Inspector's Report ACP-323024-25

Development	Proposed elevation of local tertiary road (L-52214)
Location	Cuan Na Loinge, Ceantar na nOileán, Conamara, Co. Galway
Local Authority	Galway County Council
Type of Application	Application for approval made under Section 177(AE) of the Planning and Development Act, 2000 (local authority development requiring appropriate assessment)
Prescribed Bodies	Inland Fisheries Ireland (IFI) Uisce Éireann (UE) Development Applications Unit (DAU)
Observer(s)	None.
Date of Site Inspection	27 th August 2025.
Inspector	Peadar McQuaid.

**PROPOSED SITE LAYOUT PLAN
 SAC EXTENTS**
 SCALE 1:500

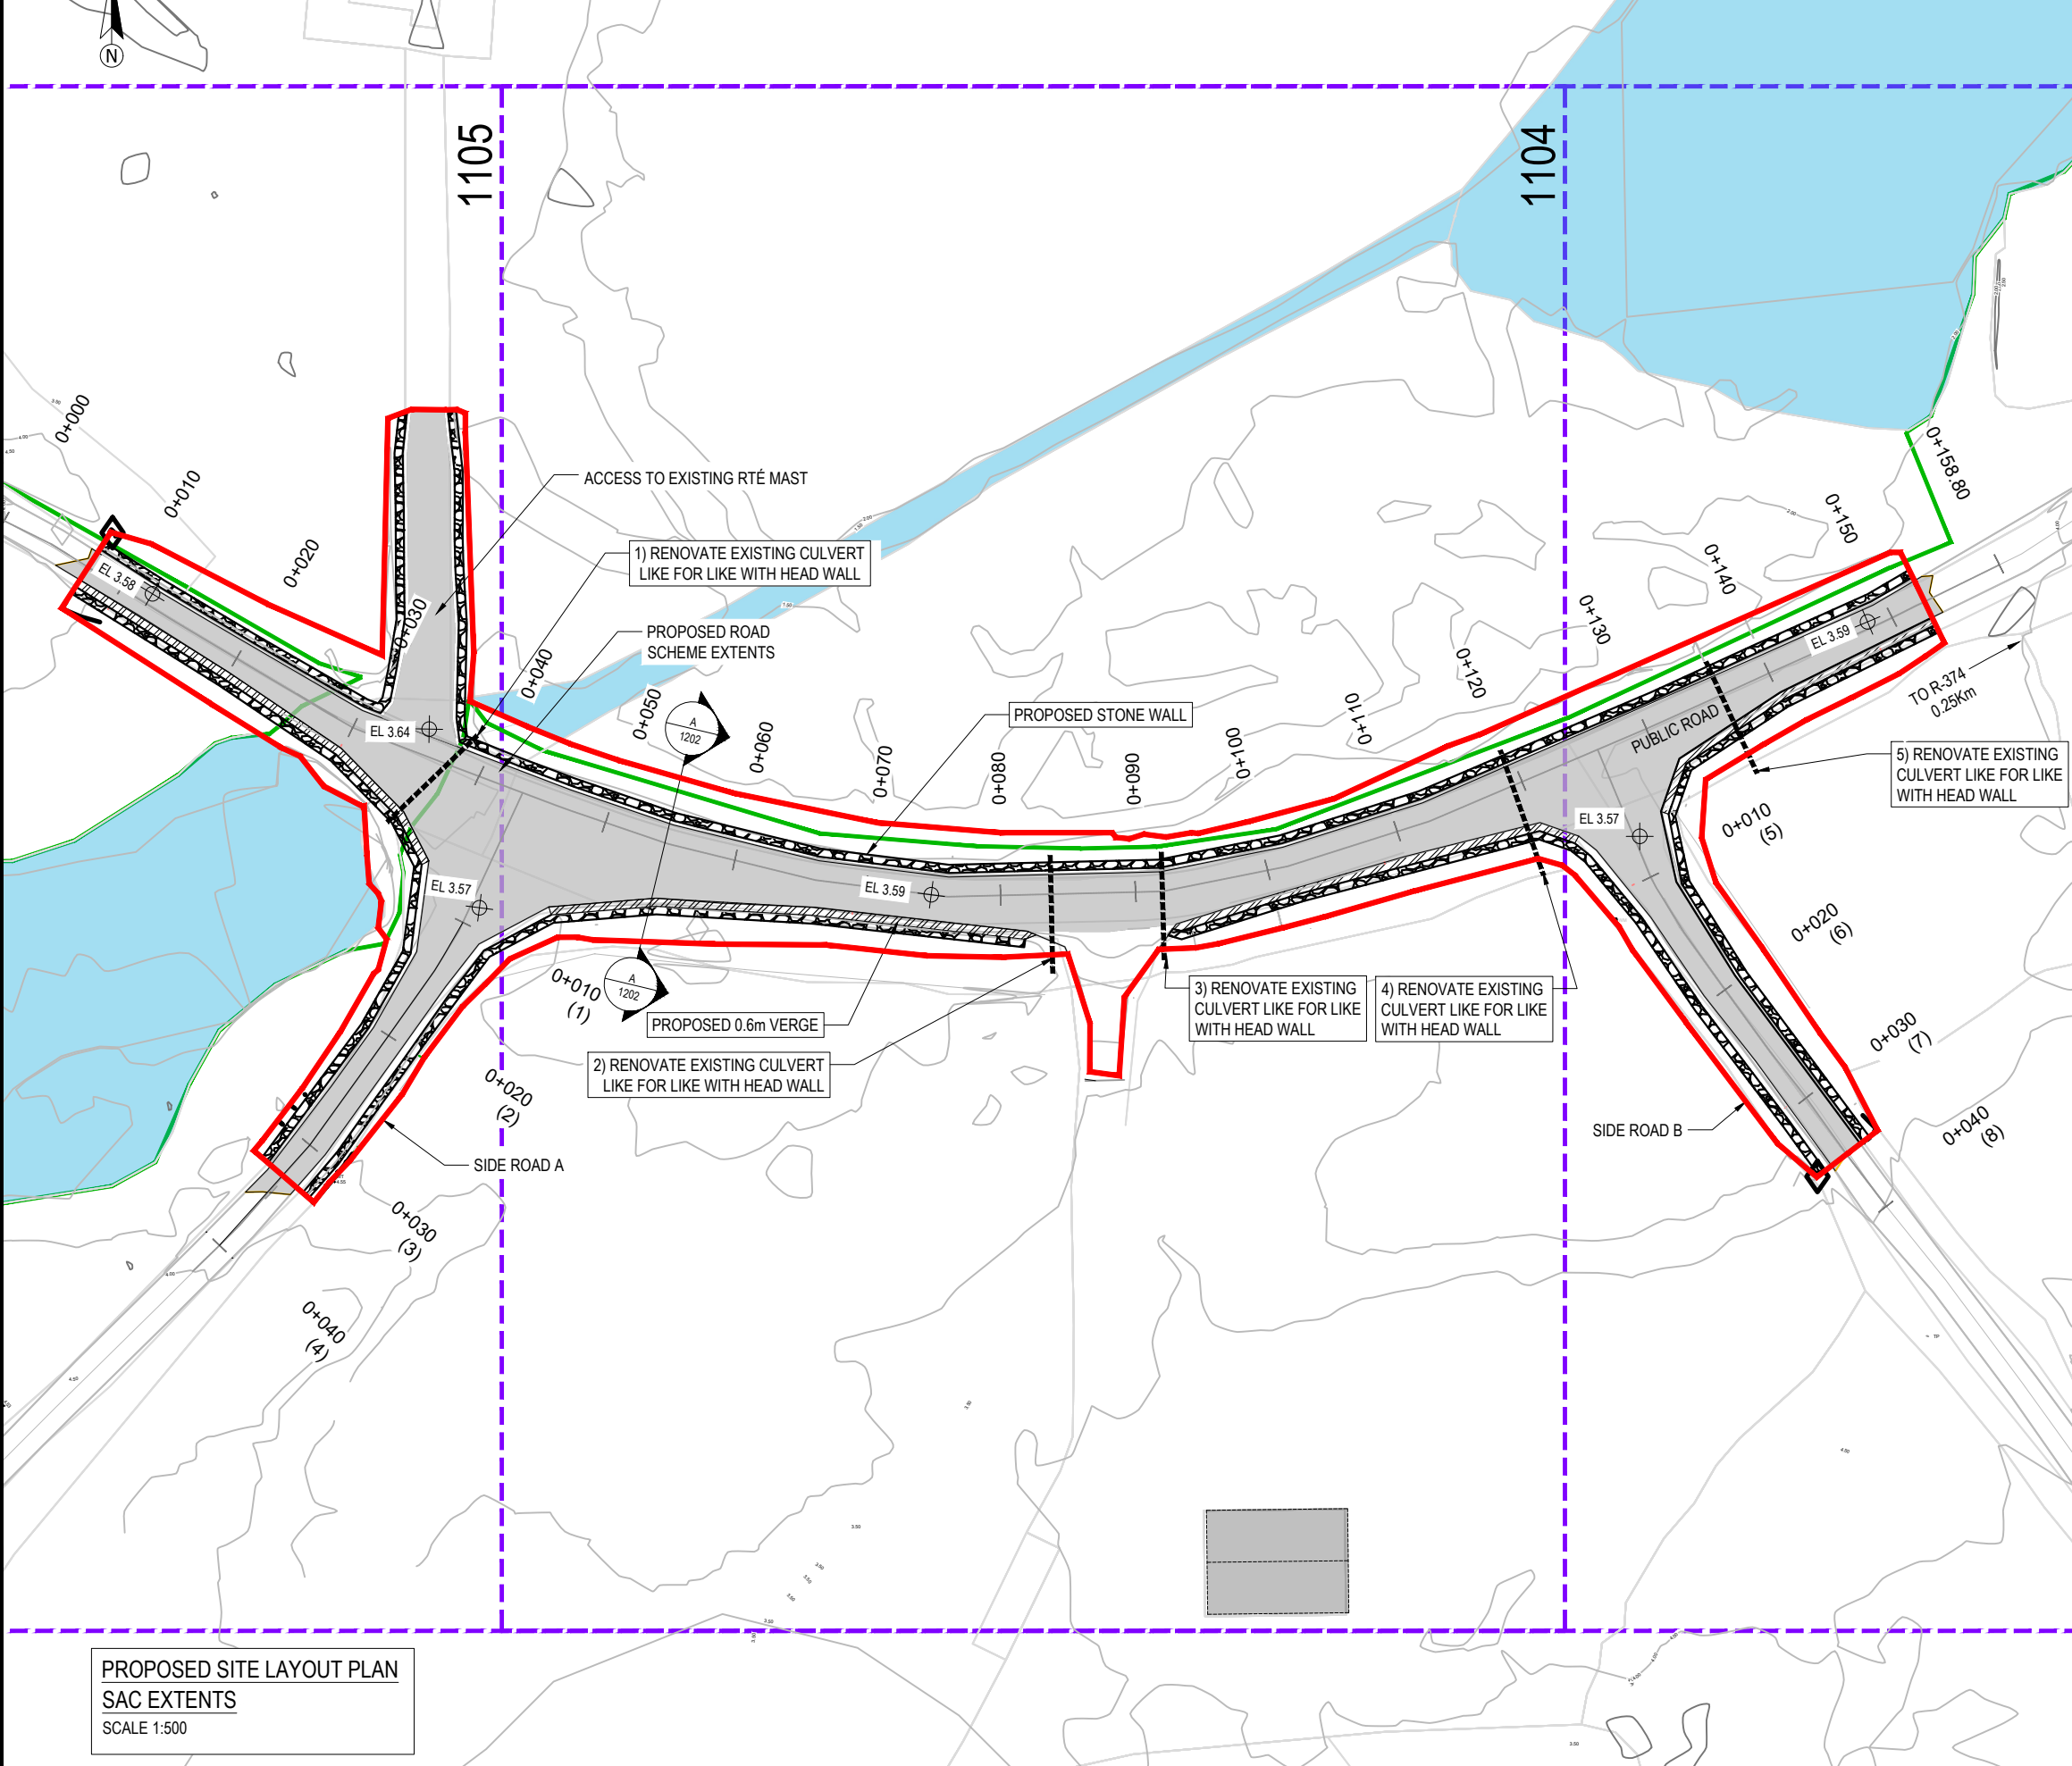
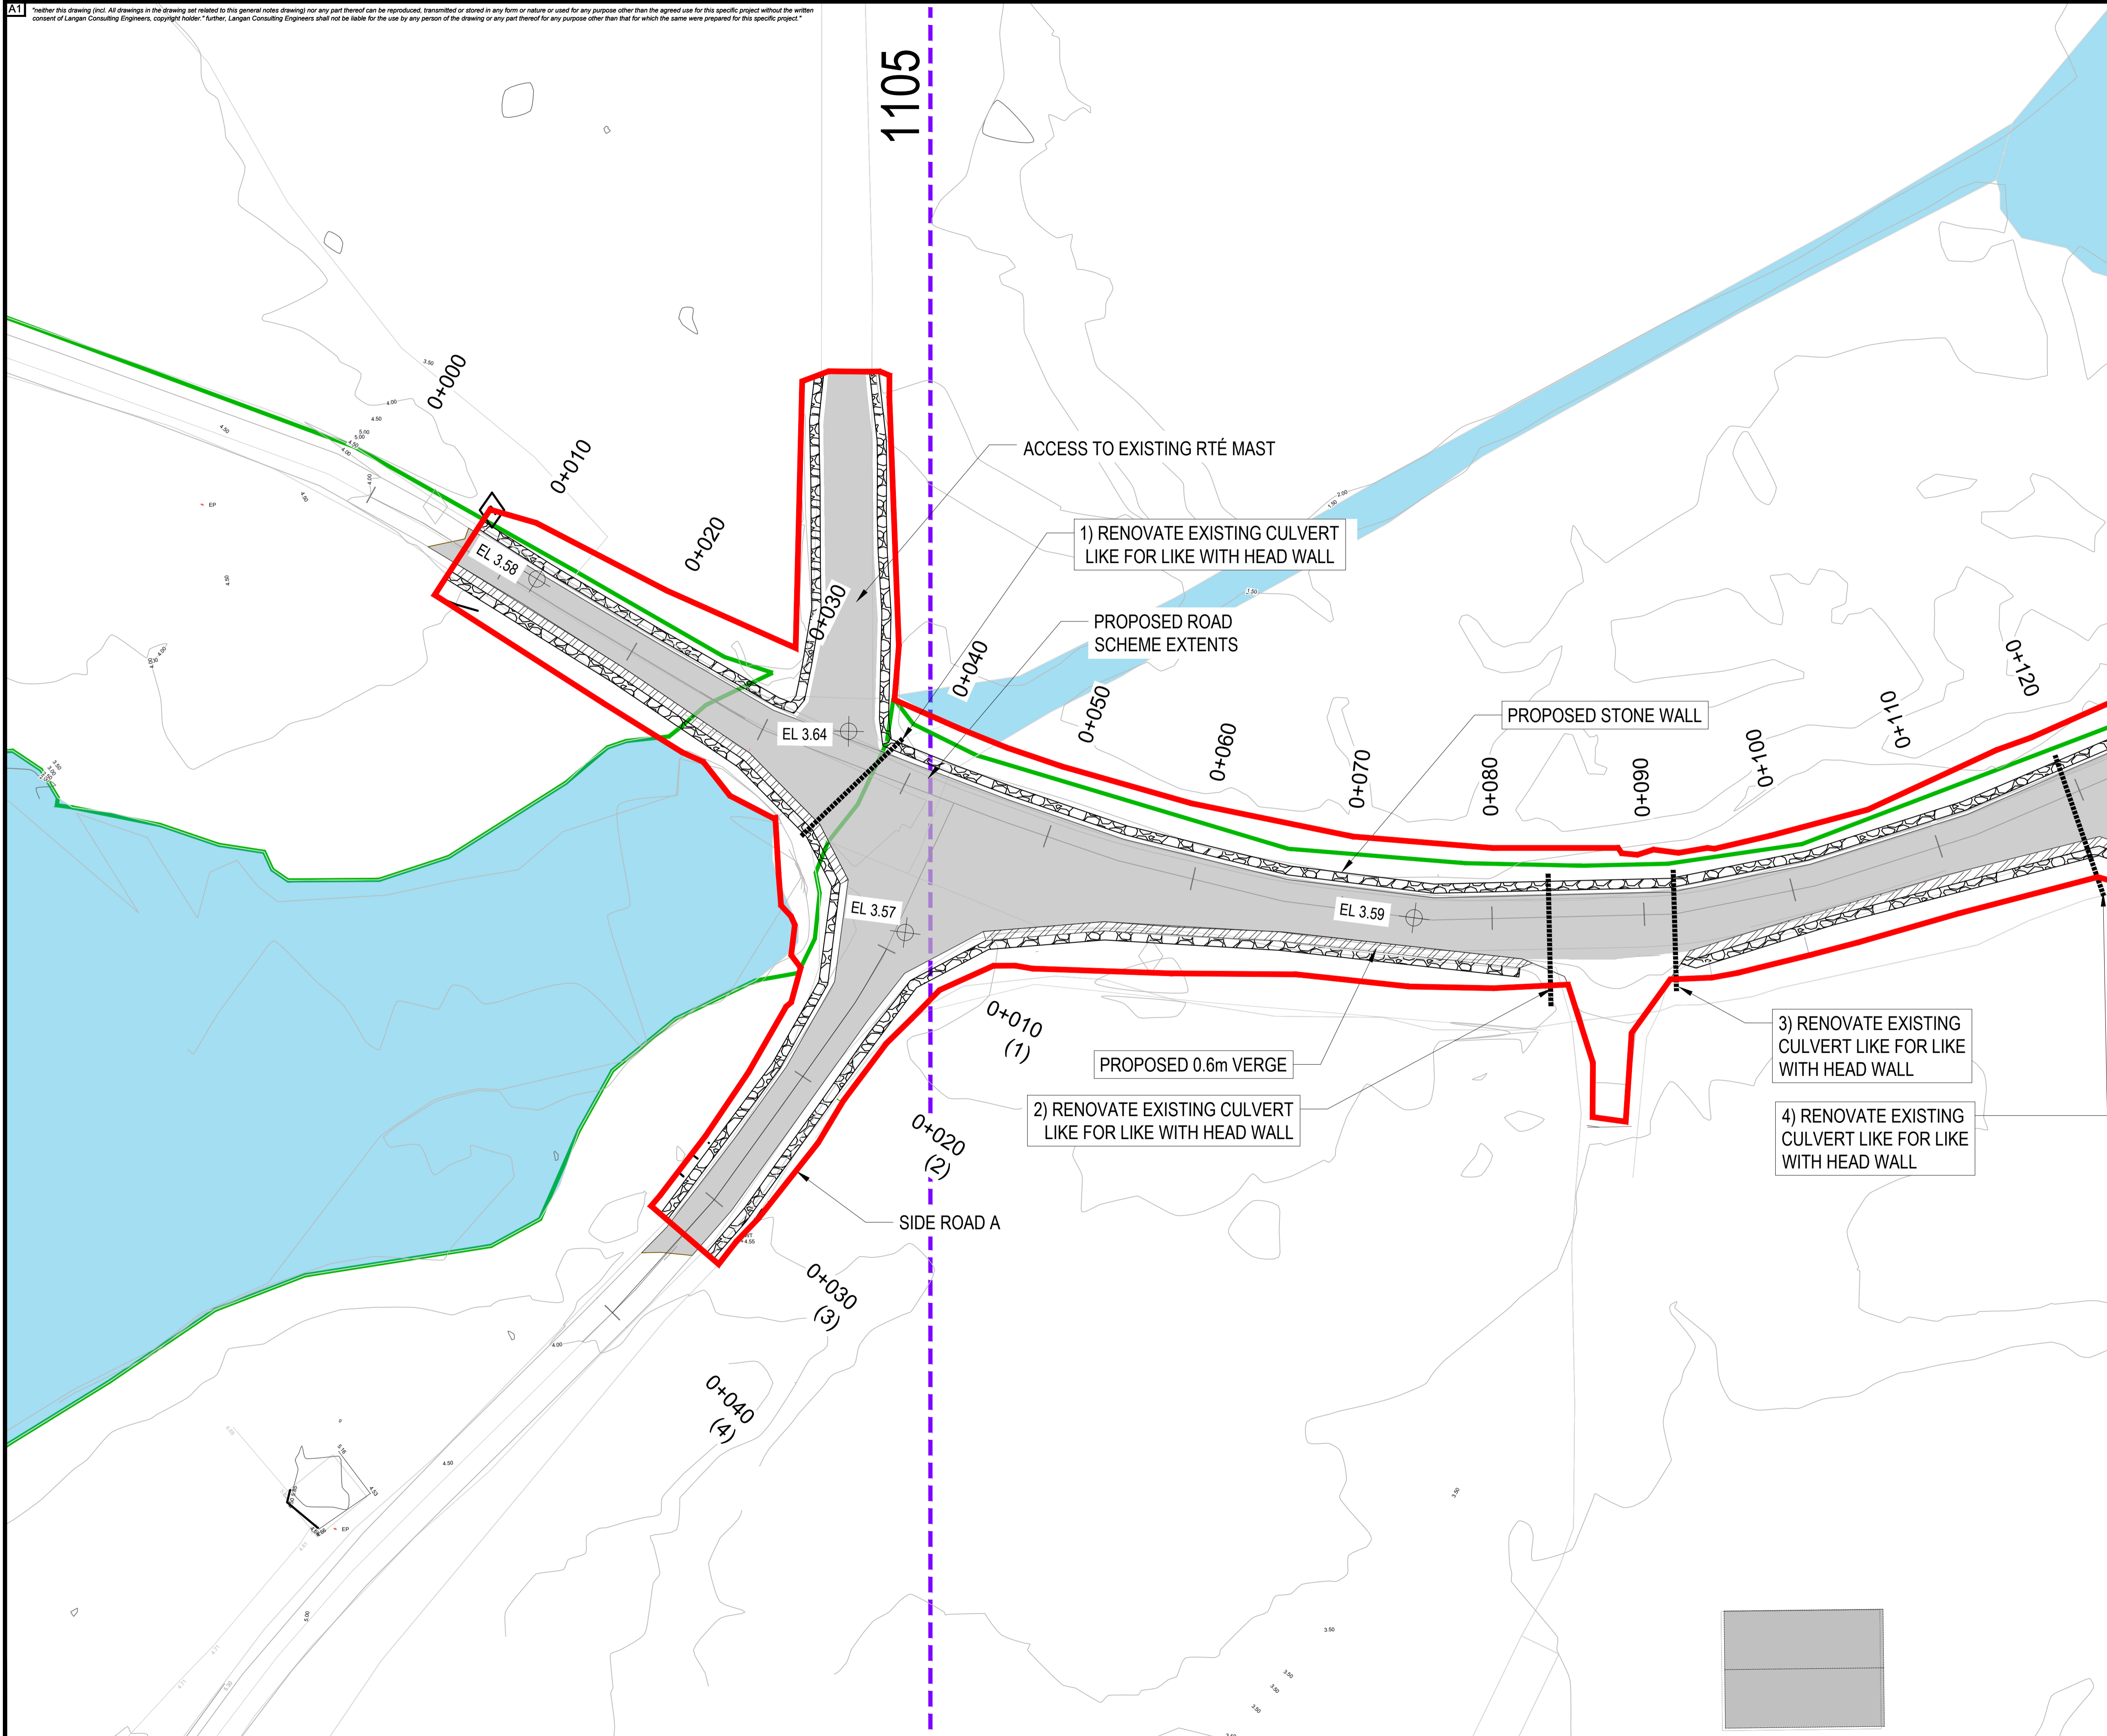
- The Department notes that the Natura Impact Statement (NIS) provided with the application does not identify that an area of the Annex I habitat Coastal Lagoon occurs immediately adjoining the proposed works (as outlined in Map 4 of NPWS, 20141). The NIS also states that there will be no direct loss of habitat within the SAC as a result of the proposed works, however, the cross-sectional diagram re-produced in the document '*Preferred scheme option report*' indicates that the rock armour, which will occur along the elevated road, will be significantly wider than the existing road.

- Consequently, there is some uncertainty as to whether the area of Coastal lagoons [1150], or Atlantic salt meadows (*Glauco-Puccinellietalia maritimae*)

[1330], will be subject to a loss of area as a result of the proposed development.

- The Department recommends that An Coimisiun is satisfied that they have sufficient information to determine that the proposed works, including the rock armour, do not extend into any areas that correspond to either the Annex I habitat Coastal lagoons [1150], or the Annex I habitat Atlantic salt meadows (*Glauco-Puccinellietalia maritima*) (f330). It is a Conservation Objective for both within the Kilkieran Bay and Islands SAC that their area be stable or increasing.

1. (a) Clarification on the presence and location of any QI habitat within the site boundary, having regard to best practice survey guidance and published research on Annex I marine and benthic/lacustrine habitats.
(b) A targeted habitat survey is required to be undertaken within the site boundary, areas proximate to and in the wider vicinity of the proposed works to inform the response to item 1 (a) above.

FI item 2 – The applicant has submitted revised drawings and cross section to show the boundary of the proposed works and the SAC. Drawing reference numbers: 24155-DG-1103, 24155-DG-1104, 24155-DG-1105 & 24155-DG-1202.

12.1.9. From a review of the revised drawings submitted (Drawing no's 1103 – 1105) and the Habitat Survey Report, I am generally satisfied that no non-EU designated Annex I habitats were identified within the proposed project footprint. Issues involving EU designated Annex I habitat are addressed in the appropriate assessment section of this report. I consider the existing/proposed road surface and associated hard standing is of negligible botanical interest.
